**Our Case Number:** ABP-308210-20

**An  
Bord  
Pleanála**

**Re:** 6 no. wind turbines.

Lackareagh and Garranereagh, Lissarda and Barnadivane (Kneeves) Teerelton, Co Cork,

## Appendix 8.3: LVIA Photomontages Book 1: VP1 - VP11

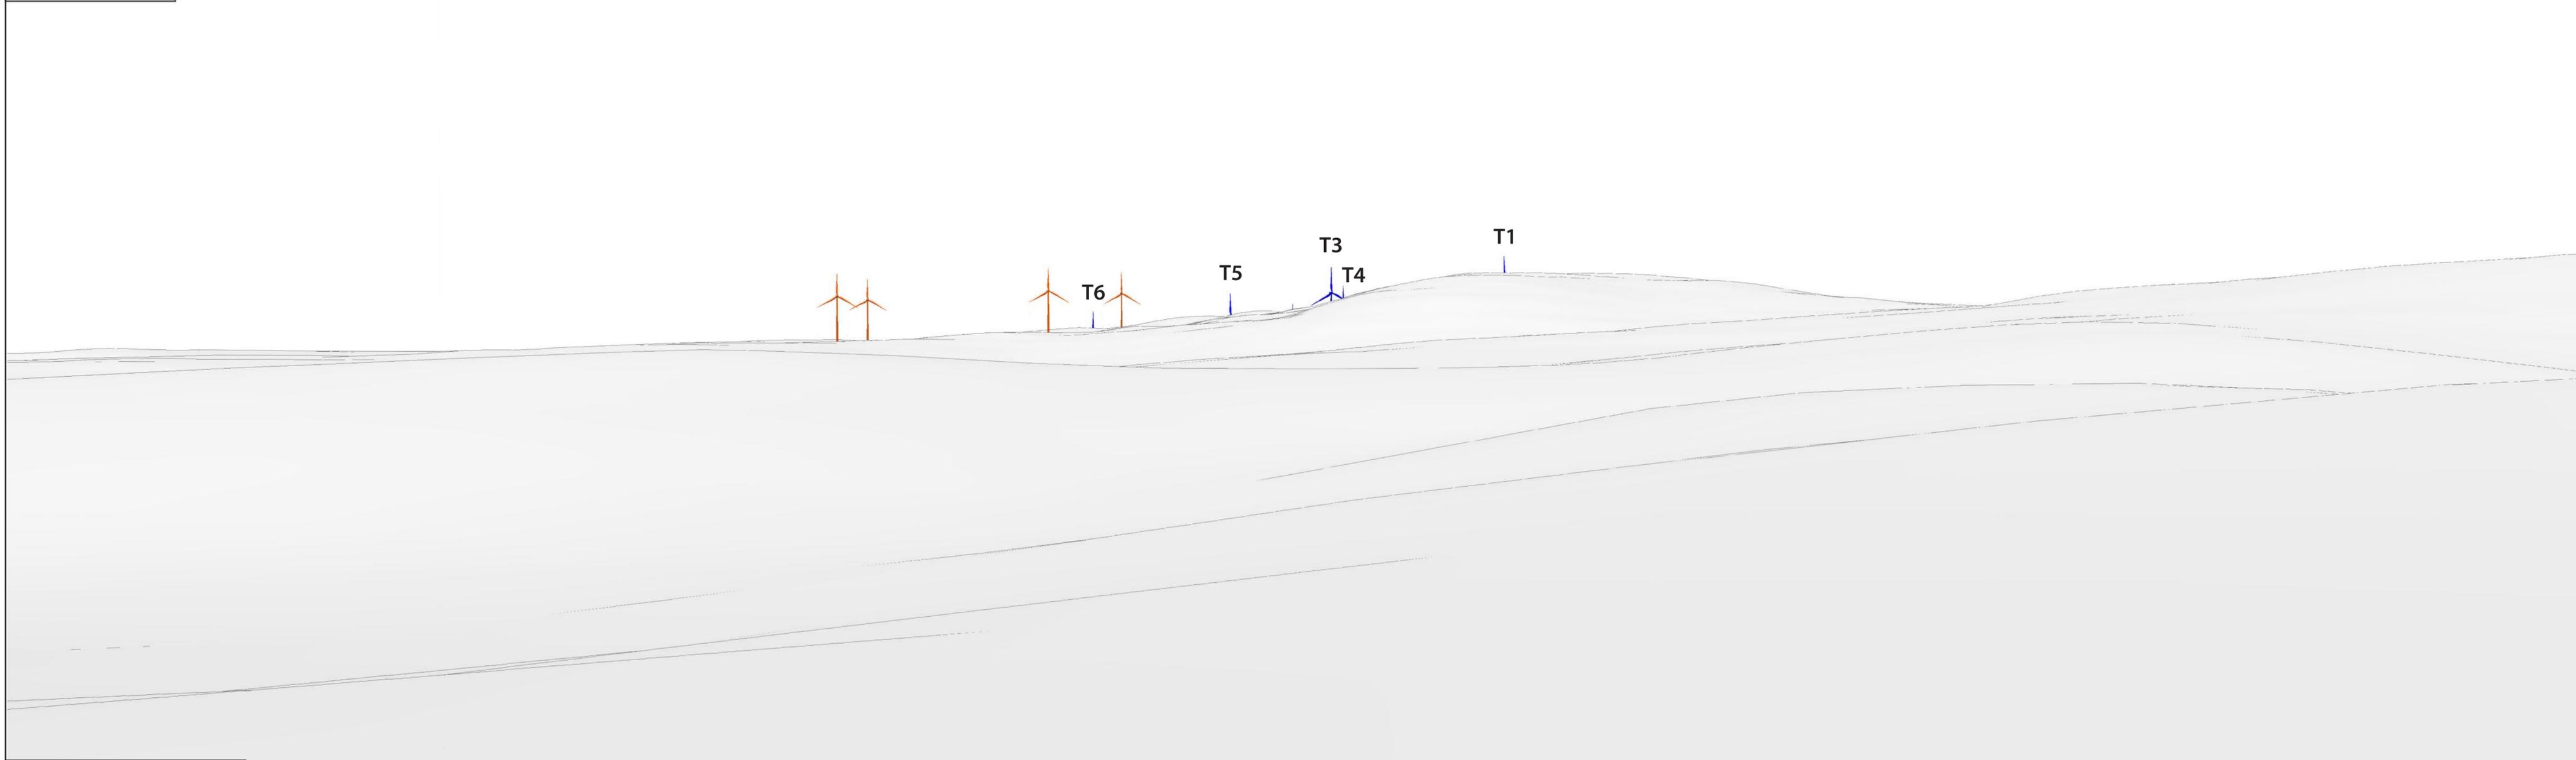
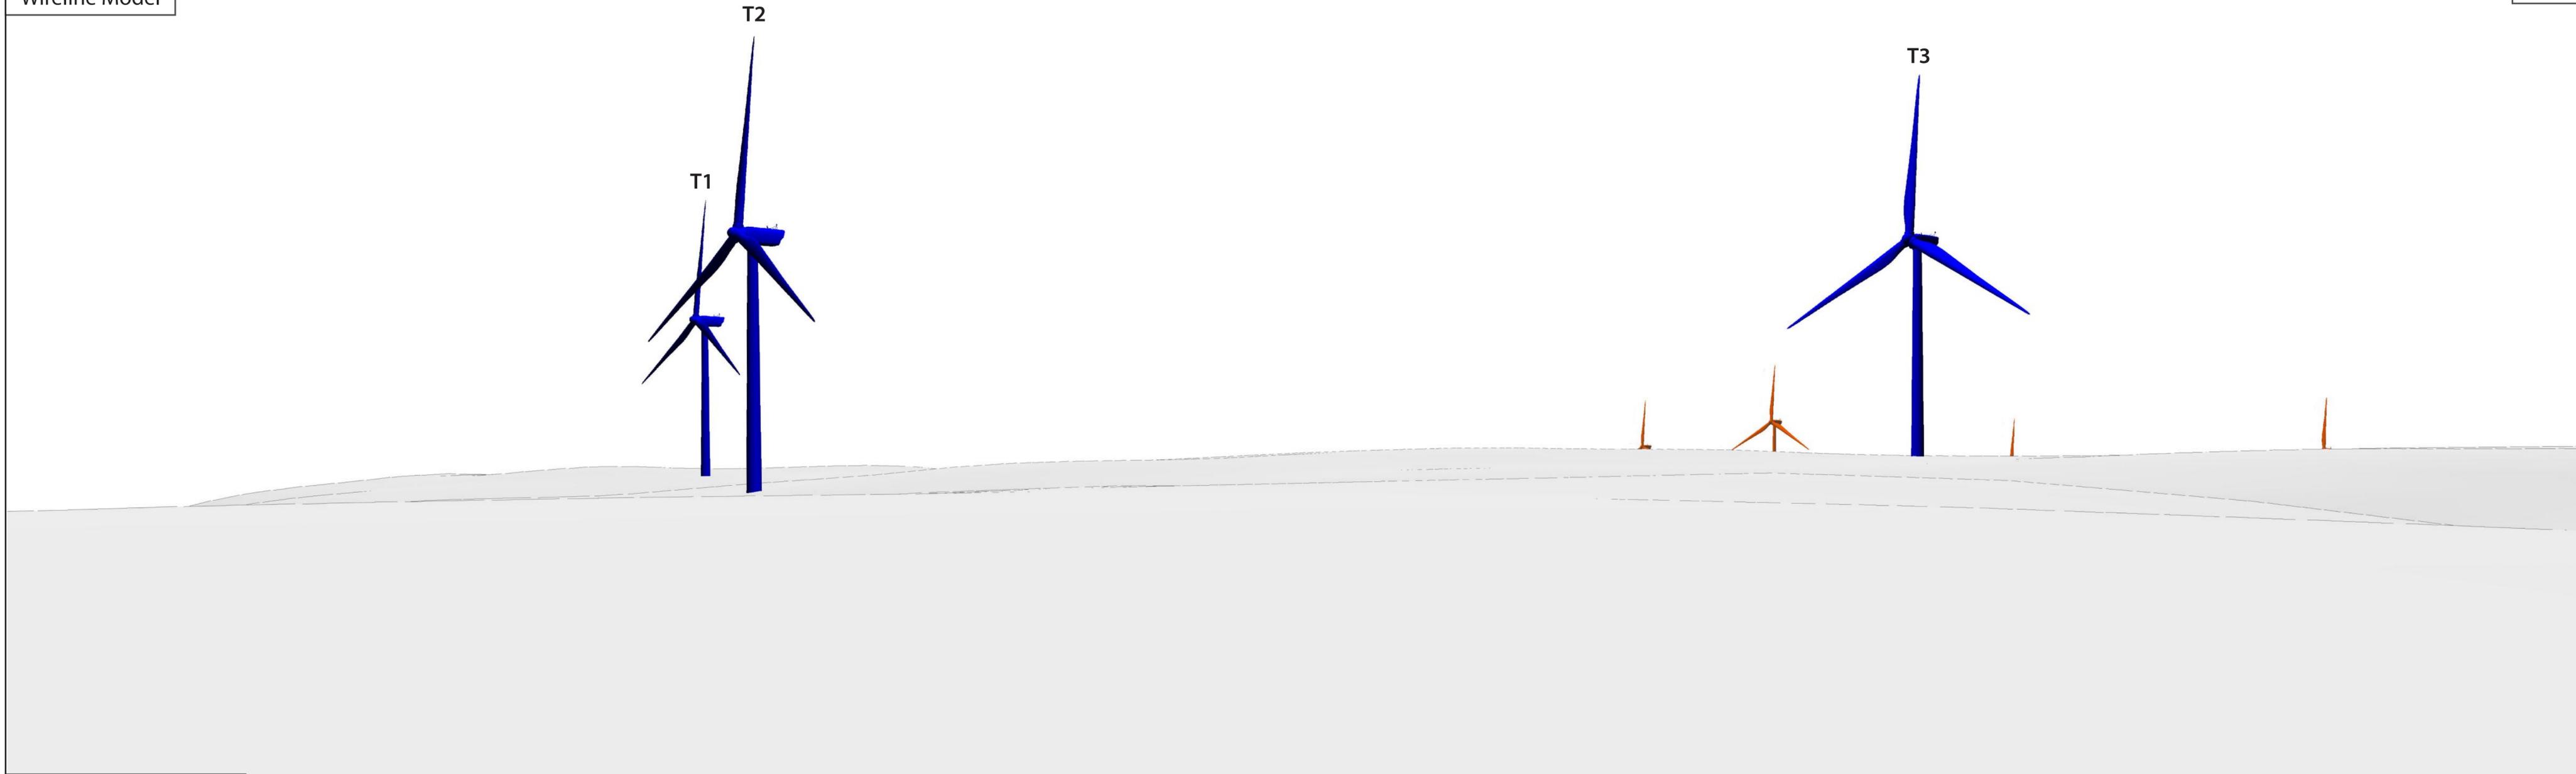
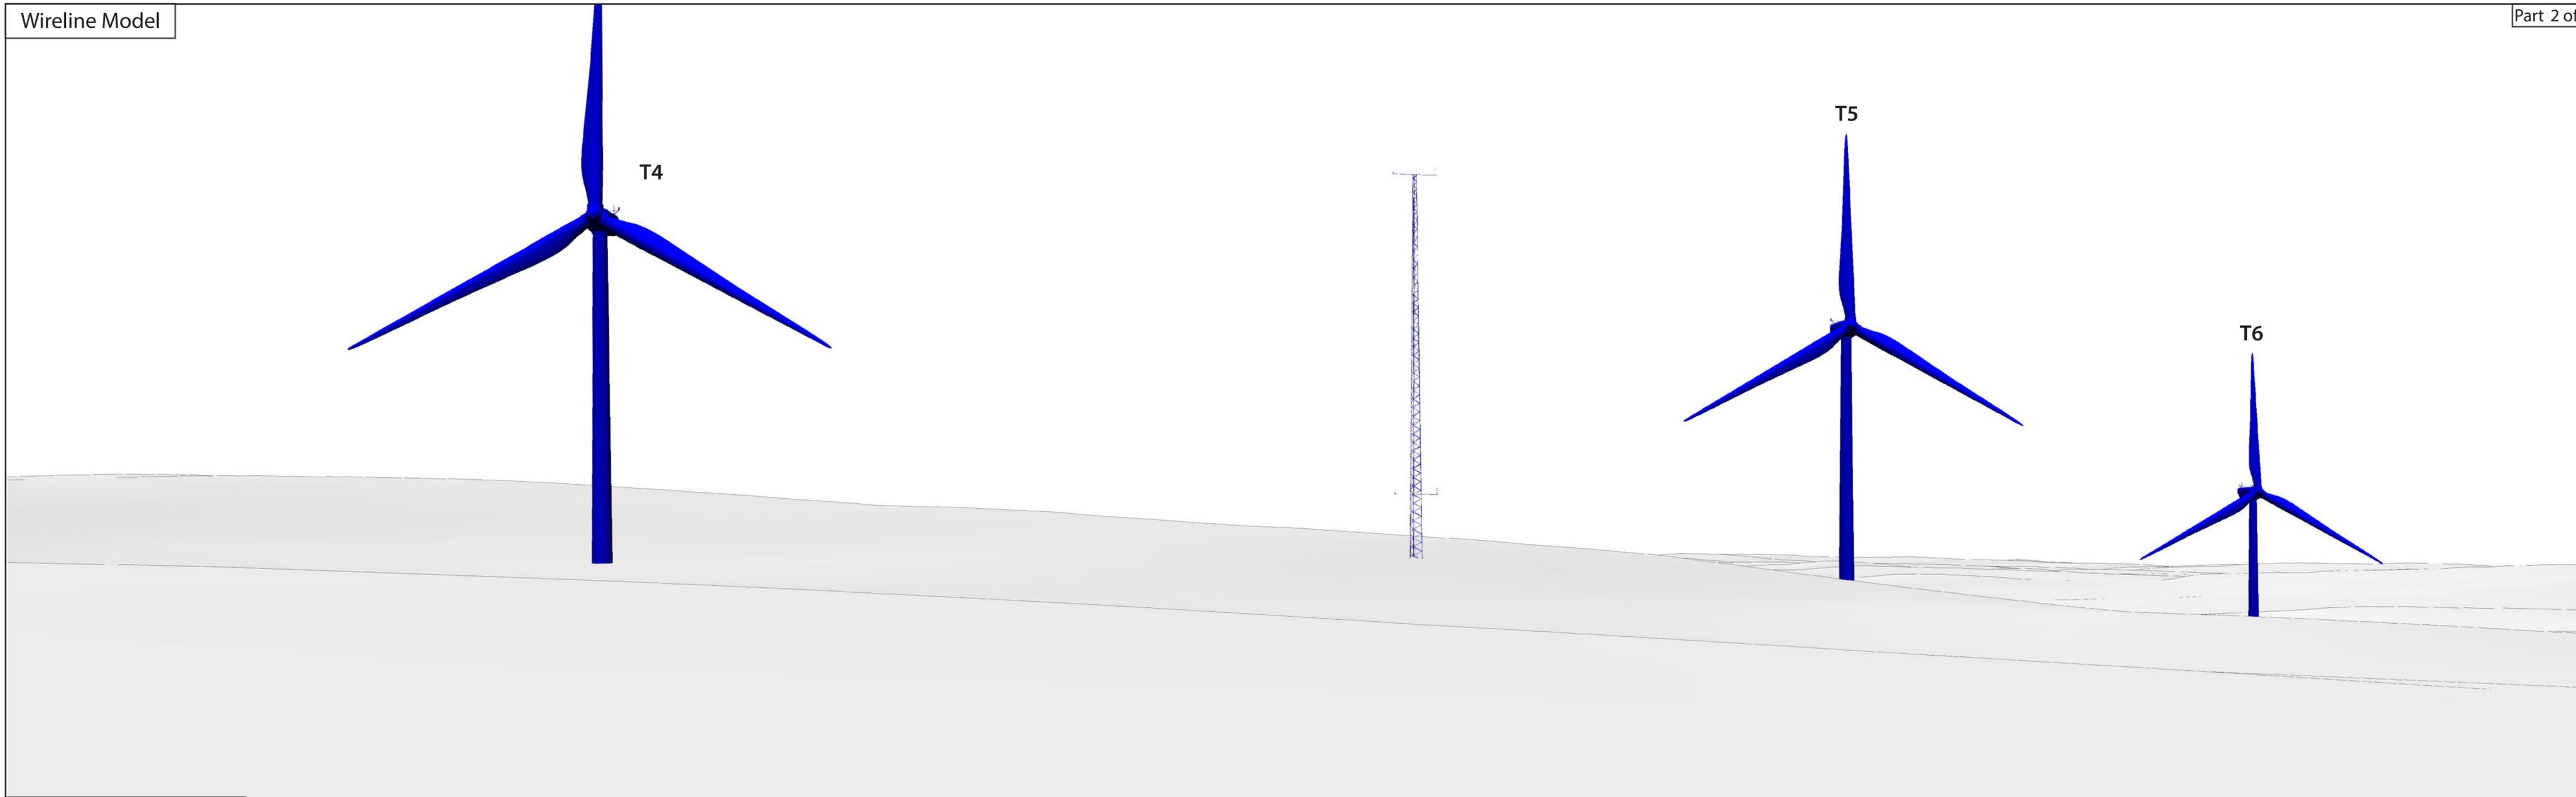
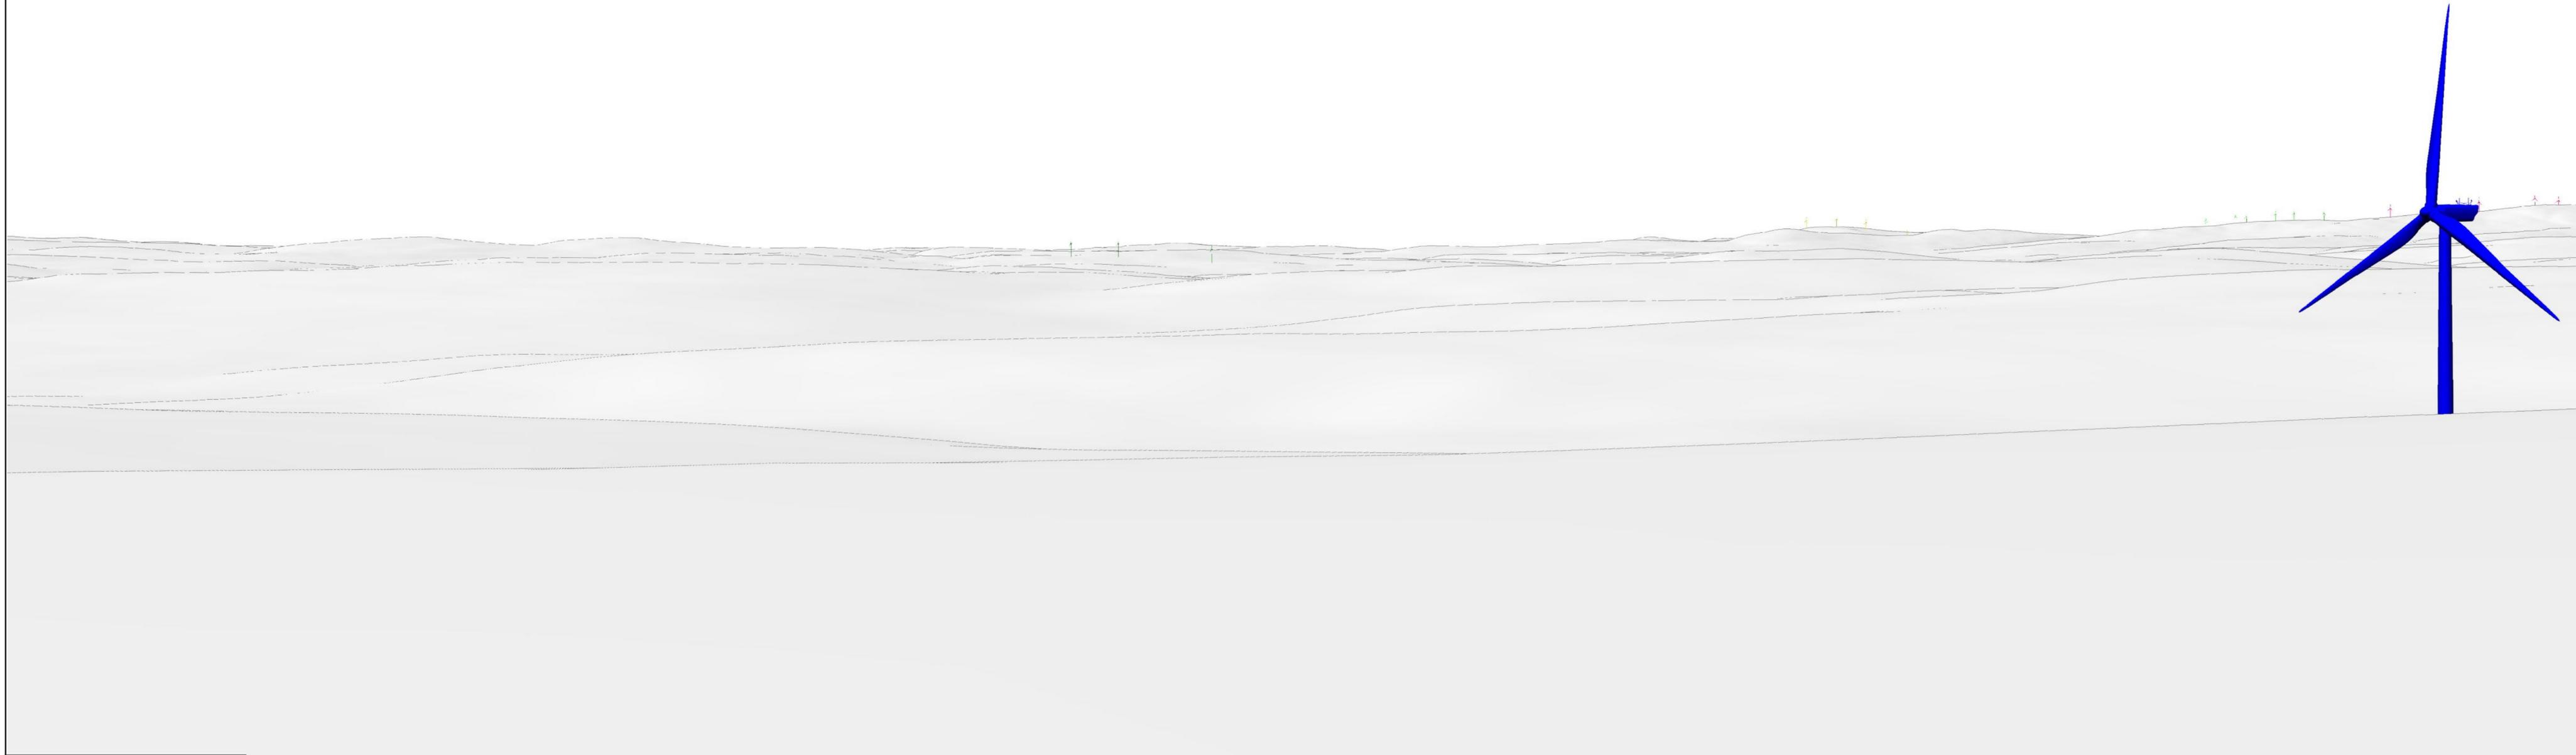
**3. You are requested to review the landscape and visual impact chapter of the EIAR and the accompanying photomontages to ensure that they are up to date and that they provide a robust consideration of cumulative impacts.**
